Application number: 2026/91547	
What is the application for?:	Change of use of residential dwelling (Use Class C3) to childrens care home for
Address of the site or building:	28, Sylvan Ridge, Huddersfield, HD2 1ZH
Postcode:	HD2 1ZH

Type of comment: An objection	
Do you wish your comments to be published on the website anonymously?	Yes
Application No: 2026/91547 this document created 1st July 2026 Case Officer: Danielle Cooper Applicant: S Yousaf List of Planning Objections and Representations to the proposed change of use to number 28 Sylvan Ridge HD2 1ZH from its current residential use (class C3) to a residential Care Home for up to two children (class C2) and external alterations to form additional parking area. 1) I object because the applicant has not demonstrated that 28 Sylvan Ridge is a safe and suitable location for vulnerable children. The recent Inspector's dismissal of the children's-home appeal at 2 Robin Hood Road (also located on our housing estate) identified serious deficiencies in site-specific safeguarding evidence. I propose the applicant provide an Impact Risk Assessment on the local crime risks, procedures to be put in place to cover unauthorised absence and

1st Floor

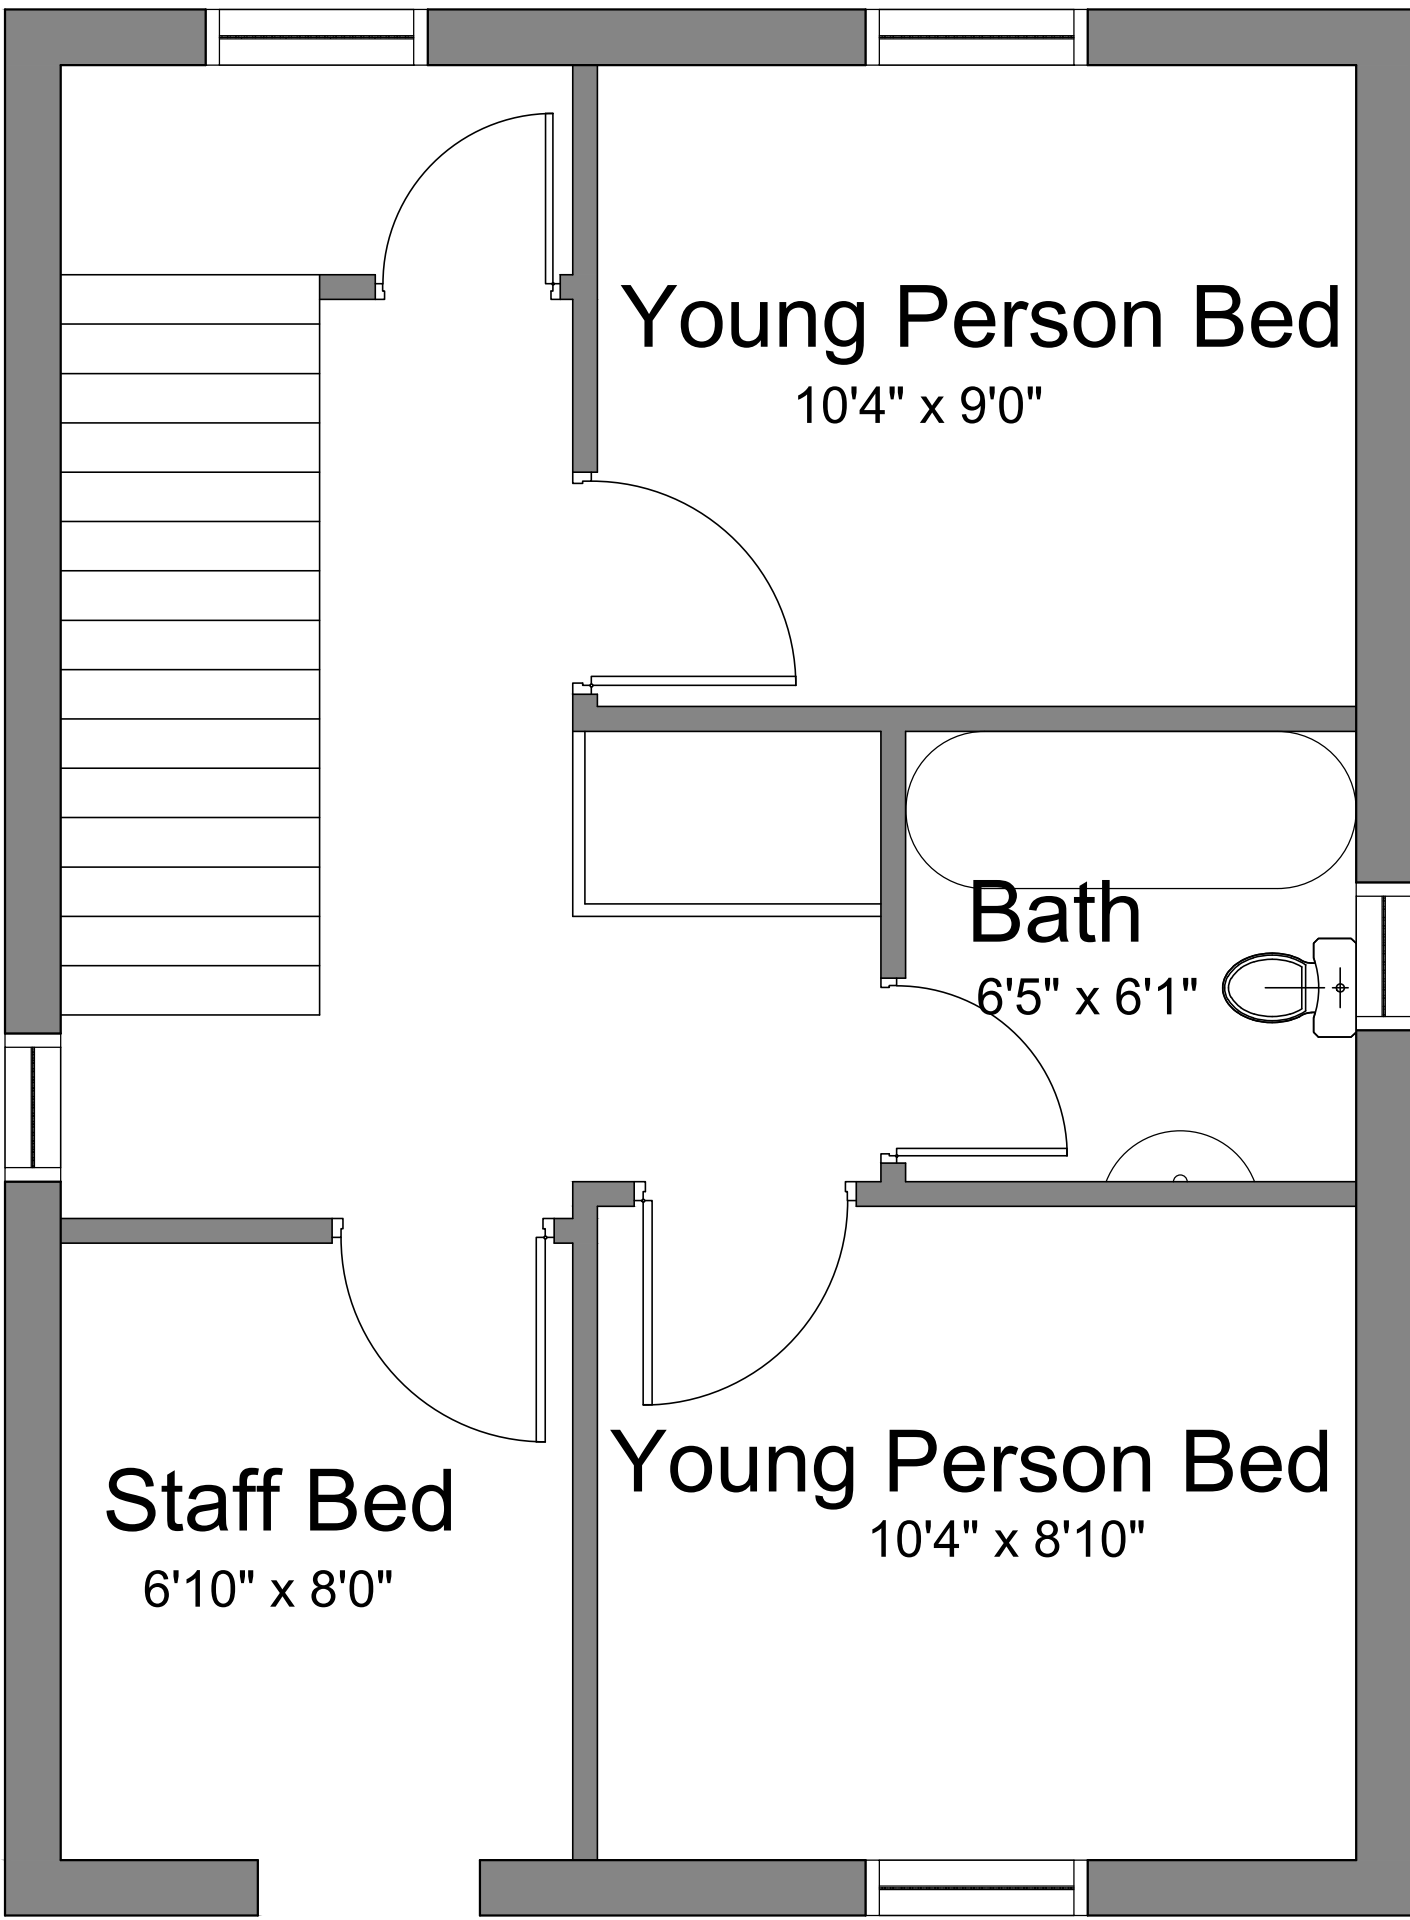
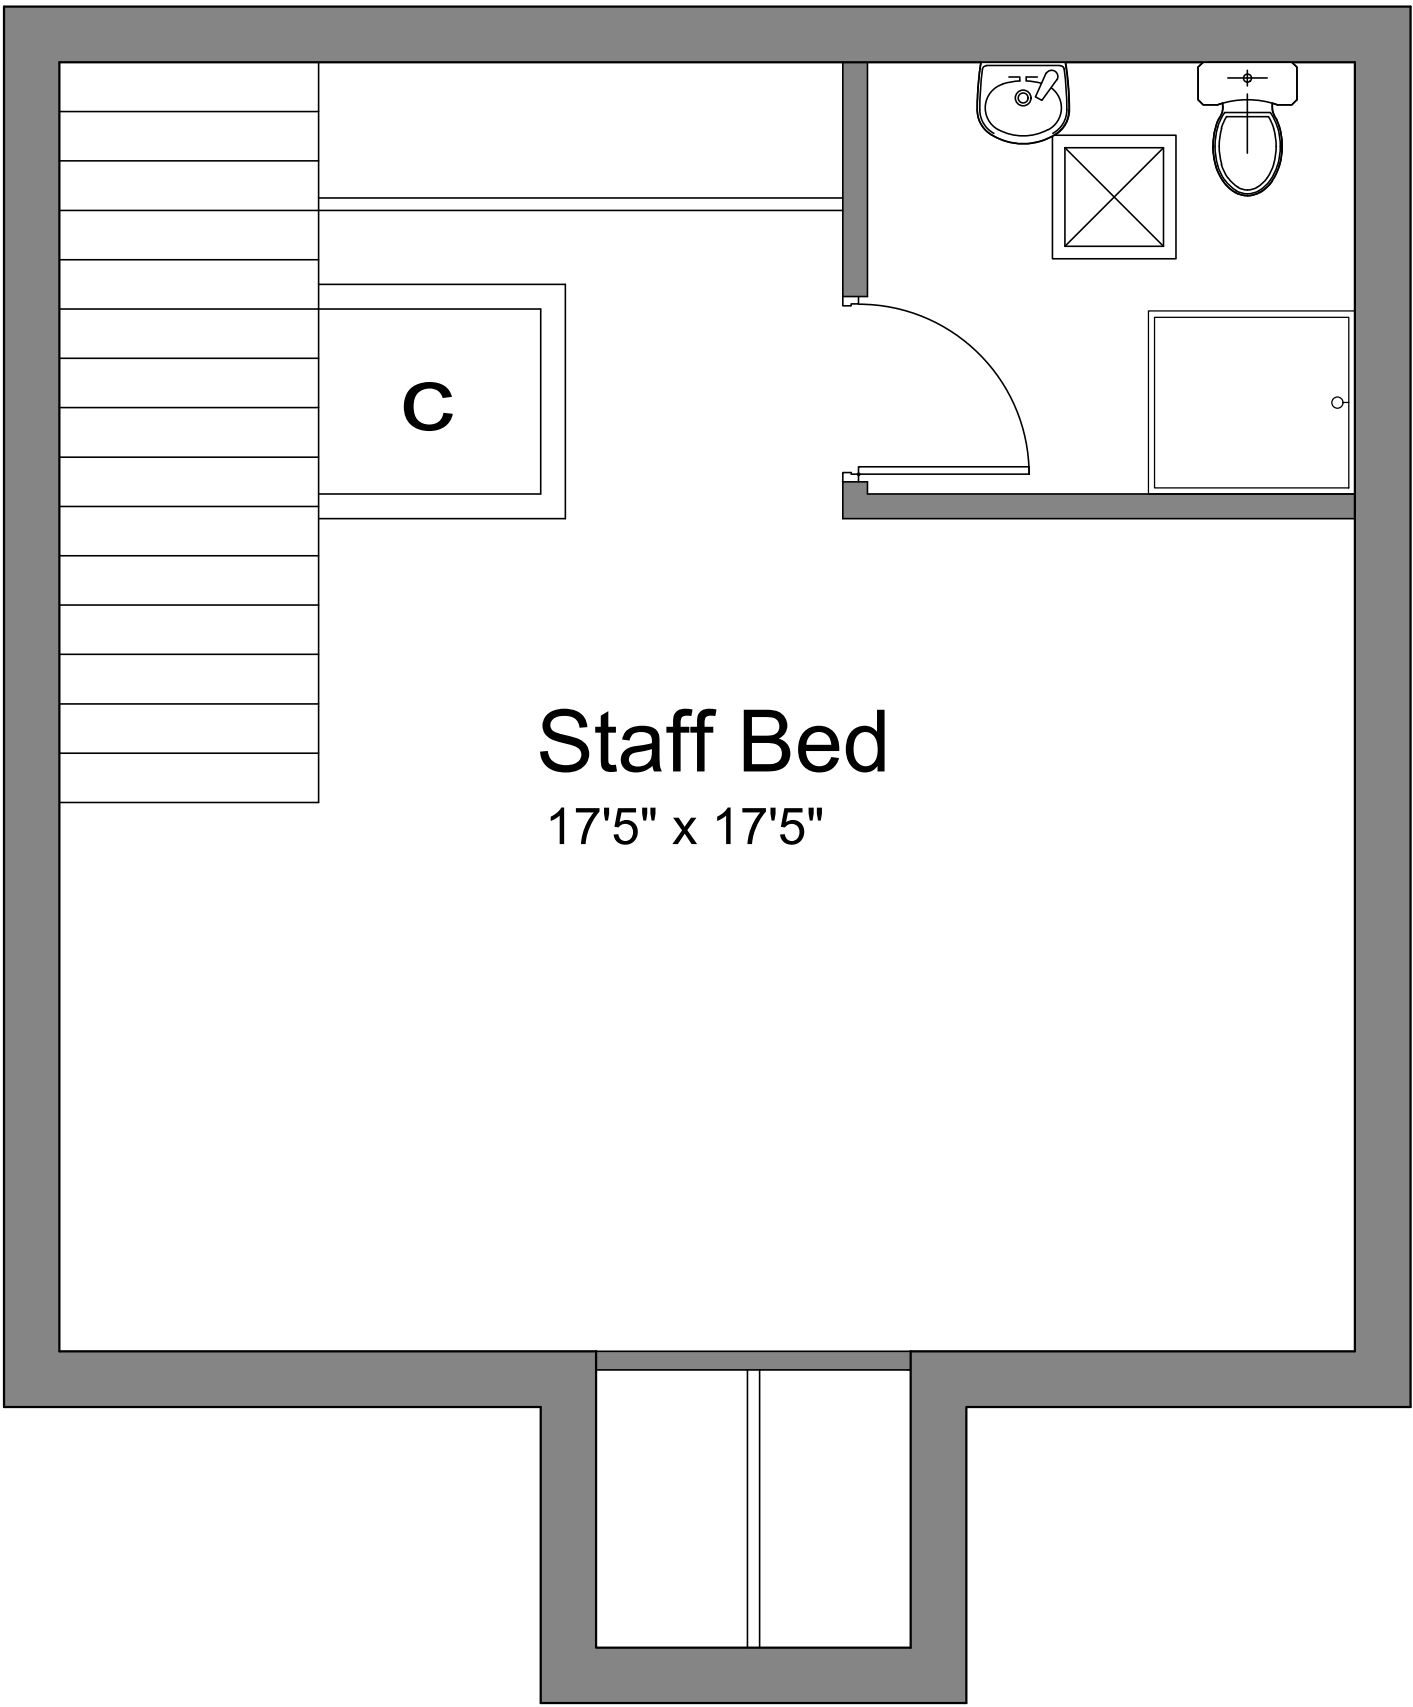
4) Staffing requirements. There are inadequate details of staffing, the plan submitted merely identifying the provision of two staff bedrooms. Further details should be submitted namely the number of staff to be employed, their qualifications, their rota and shift patterns plus managerial staff. Provision for cleaning the premises and cooking the meals. This would help establish the intended seriousness of the application to the surrounding residents.

BLOCK PLAN

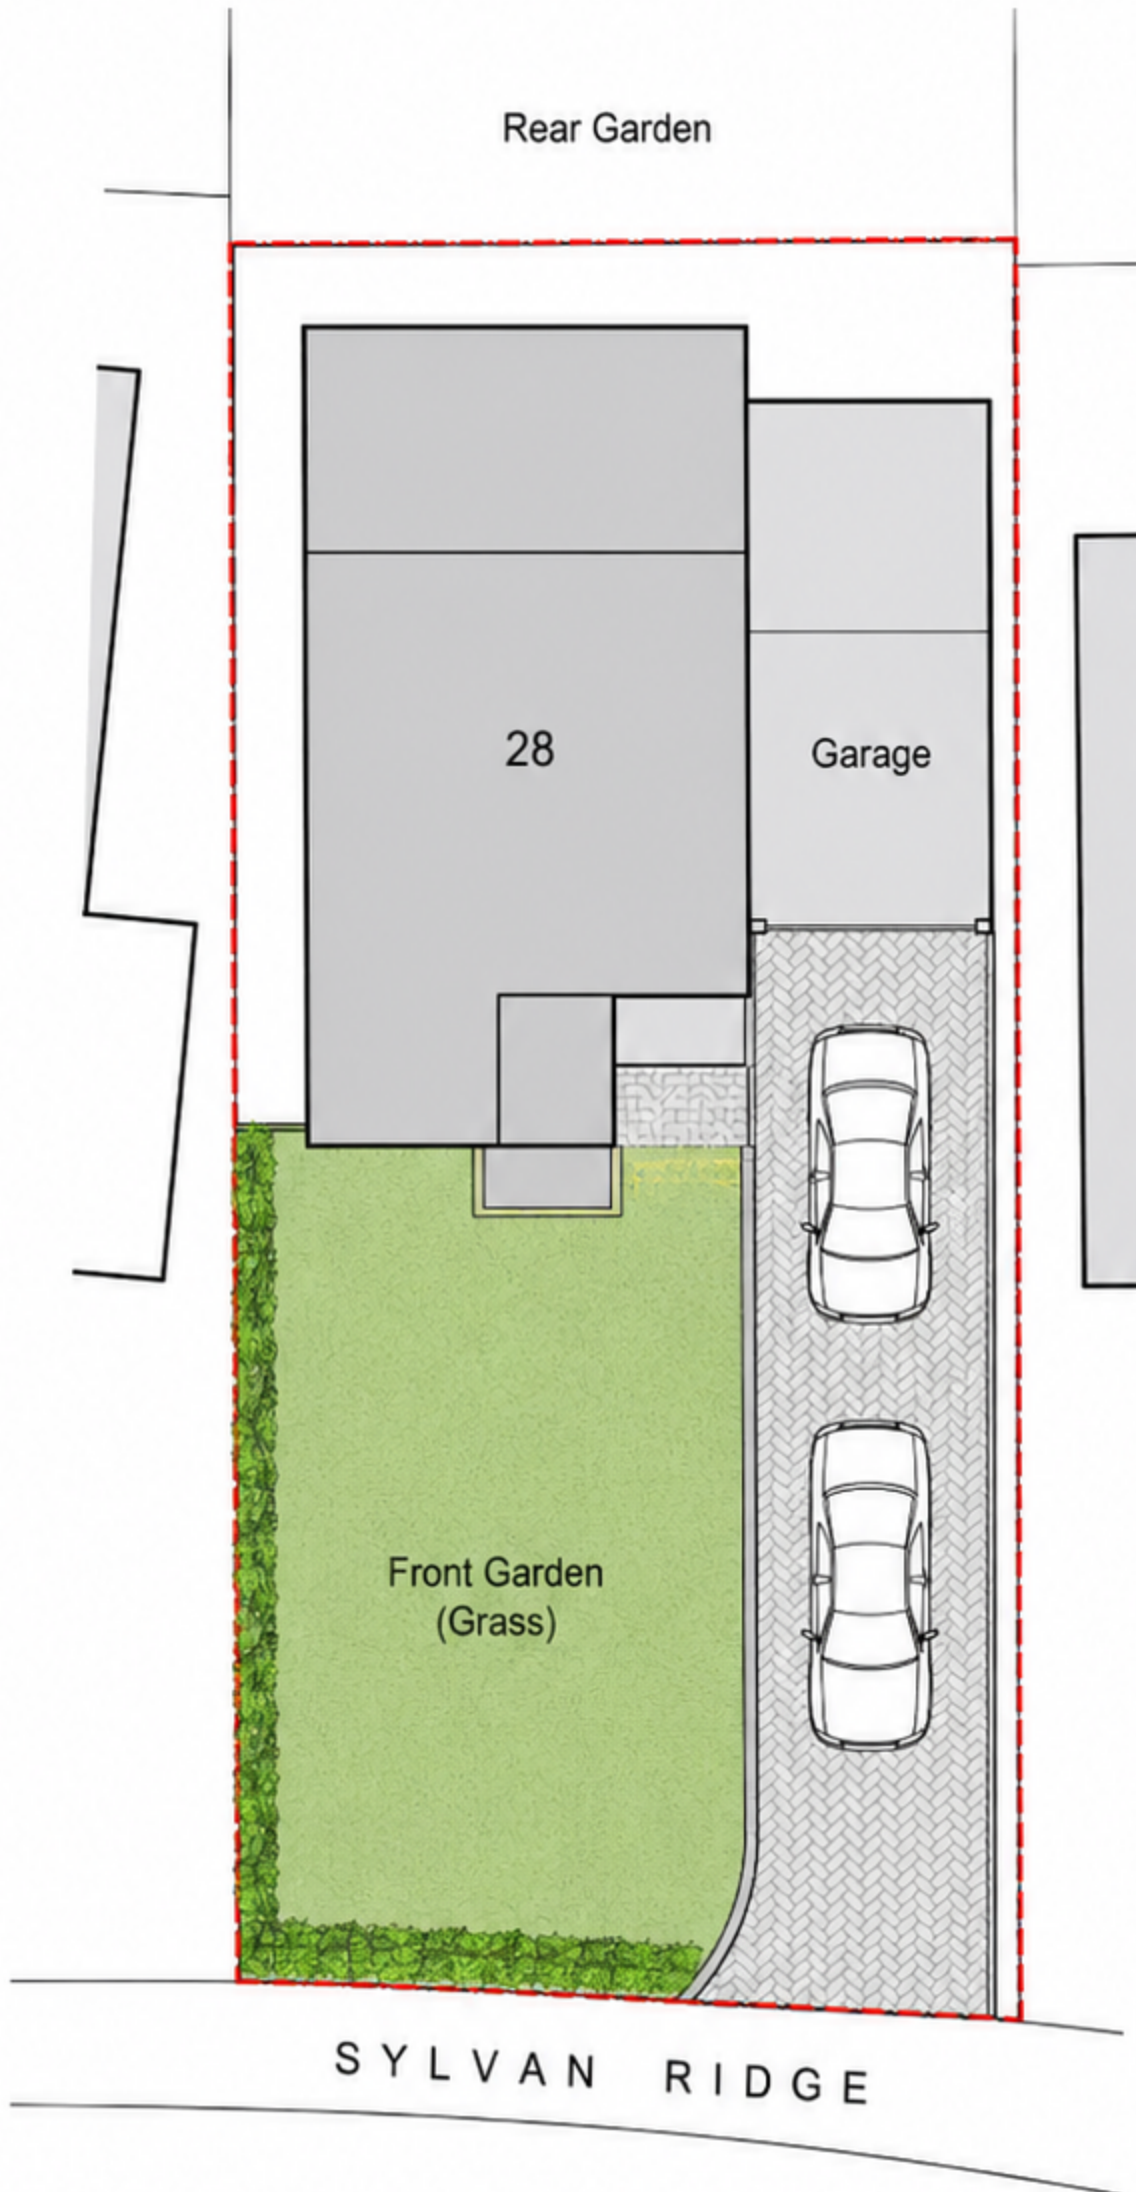
by the Applicant. The only way to increase on-street parking is to hard-surface the existing grass lawn to the left of the drive. The Applicant has applied for separate planning permission to do this. The Applicant's block plan is very misleading in that the lawn is shown much bigger than it is in reality. The lawn is drawn at double the width of the adjacent drive implying there is plenty room to create two more car parking spaces. Site measurements establish the drive is 2.80 metres wide but the lawn next to it is only 2.30 metres wide. If the original planners determined a width of 2.80 metres was necessary to allow the unrestricted opening of the car doors on both sides of the car, then is 2.30 metres too narrow a width? The Applicant should provide a fully dimensioned drawn to scale block plan to illustrate the actual size width of the lawn in contrast to the existing width of the drive. Further details of the conversion of the lawn to a car park should be submitted to planning. These include the type of surface material to be used, is it permeable, are extra water run-off drains to be installed, the amount of landscaping that would be removed or retained specifically the mature hedge forming the left-hand boundary of the lawn.
